North of Sefter Road, Pagham – P/88/22/DOC Comments Tracker				Initial Issue Date: 12-10-2022 Issue Date: - Revision 1.2	
	ADC Drainage Comments 11-10-22	Applicants Response	ADC Drainage Comments 18-11-22	Applicants Response	ADC Drainage Comments 25-01-23
I hereby confirm the surface water drainage design and maintenance manual is satisfactory and recommend discharge of conditions 10 & 12.					
ADC Drainage Comments 24-05-23					
The updated information supplied April 23 reflects on the variation from the geocellular tank reverting back to an open surface water basin (Ref:5) with the footpath conflict issue removed. I understand the matter of the footpath routing will be reviewed on the future phasing.					
We are satisfied that all comments previously raised are closed (see below).					
The updated drawings, supporting information and calculations are acceptable.					
	Initial/Planning:

Drawing Number			
10768/1605			
Rev			
P7

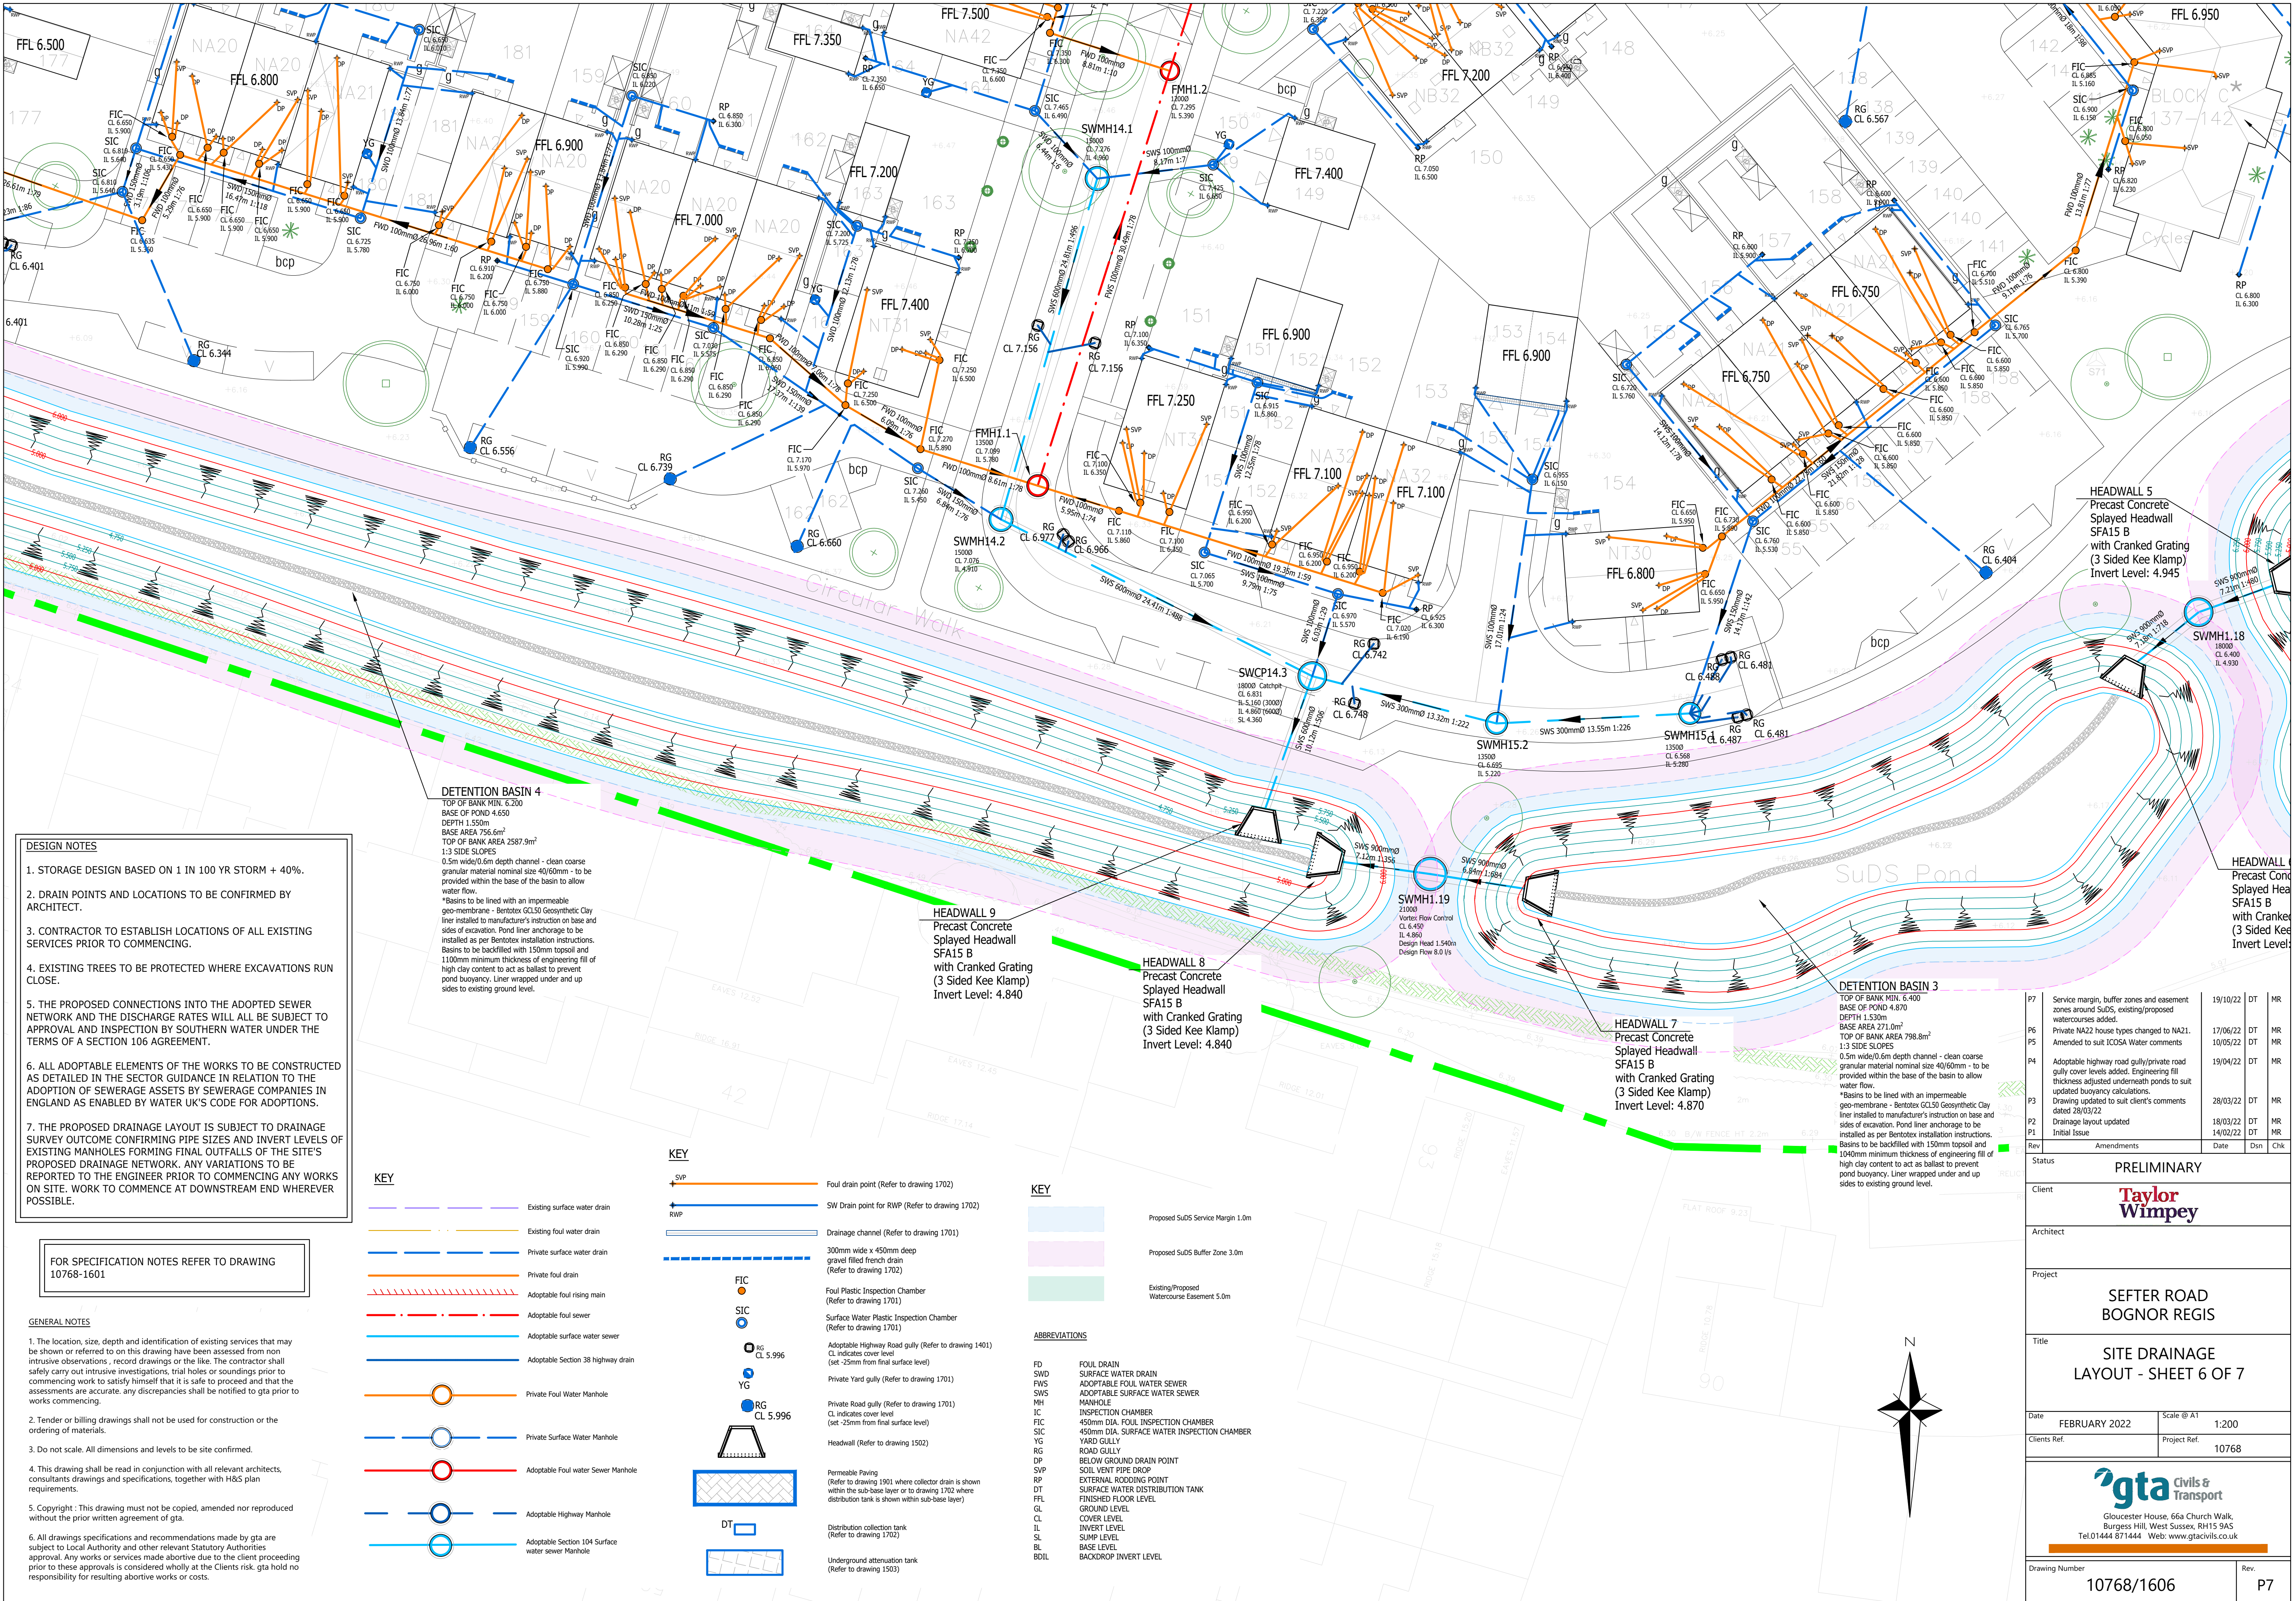
LPA Policy:				
8.	Engineering drawing must show 3.0m buffer zones from all SuDS features & the anti-tank ditch route.	Buffer zone hatched areas added on drawings 10768/1601-1607.	Agreed and closed.	-

9.	Engineering drawing must show 5.0m easement zones from all ordinary watercourses. The existing watercourses are on the topographical survey, however are not clear; suggest these are subtly hatched to stand out.	Easement zones added on drawings 10768/1601-1607	Noted, however the existing ditch corridors are very faint on the pdf's. please can these be enhanced. (See note 7 above)	Noted, the hatch on these have been amended, see enclosed latest plans.	Noted and Closed.

Status	PRELIMINARY
Client	Taylor Wimpey
Architect	
Project	SEFTER ROAD BOGNOR REGIS
Title	SITE DRAINAGE LAYOUT SHEET 1 OF 7
Date	FEBRUARY 2022
Scale to A0	1:200
Clients Ref.	Project Ref.
10768	10768
Drawing Number	10768/1601
Rev.	P11

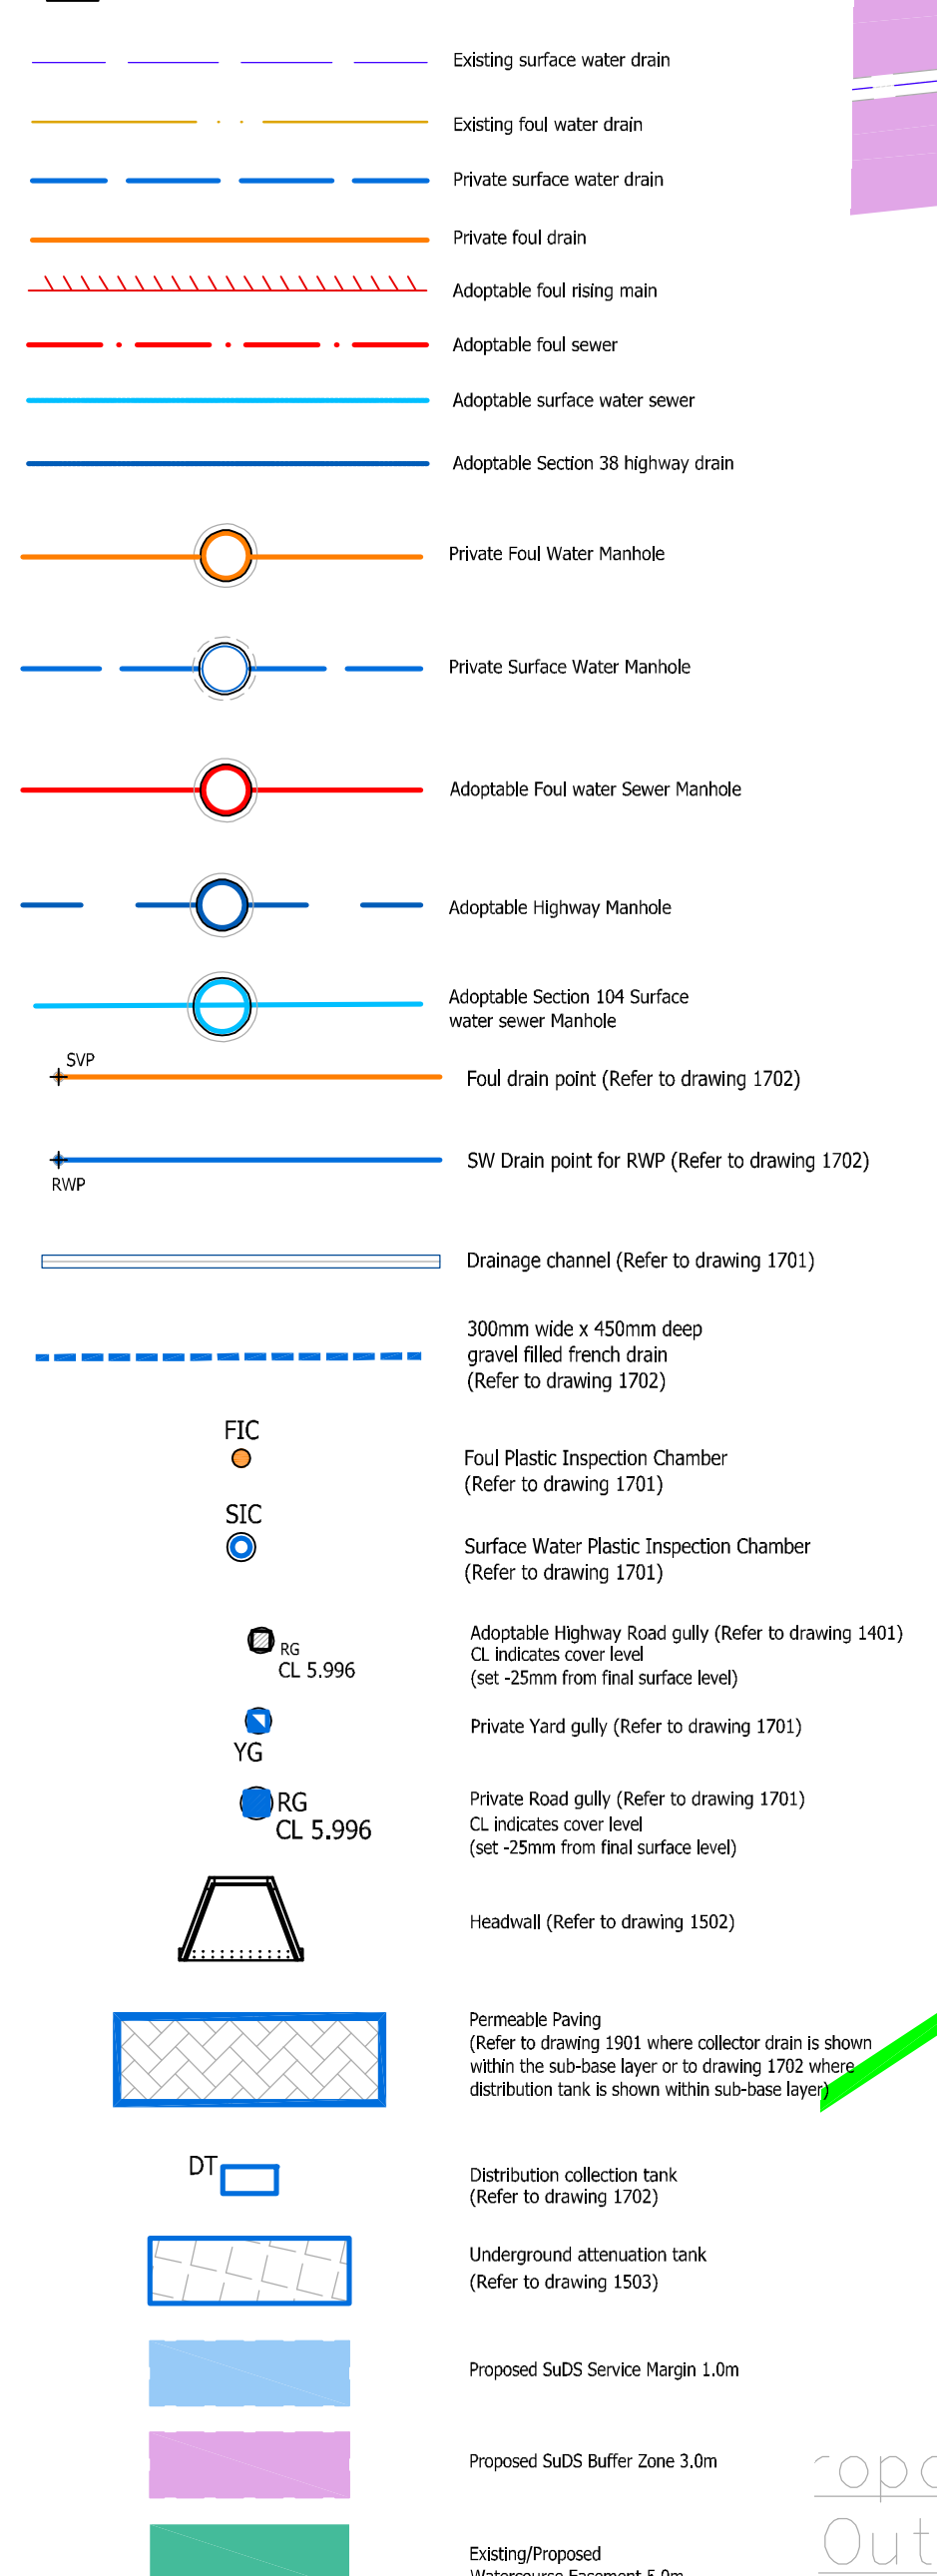
51.	Please advise if there are any areas of permeable pavement affected by groundwater. Where applicable provide further calculations.	N/A	Noted, however the area denoted on drawing 1601 are lower lying; please qualify the GW levels and formations.	The surface levels of the permeable paving are typically raised up higher than the existing ground level, with the formation on or slightly above the existing ground level. Therefore, groundwater will not affect the permeable paving construction.	Noted and Closed.
	Drainage & Maintenance Manual:
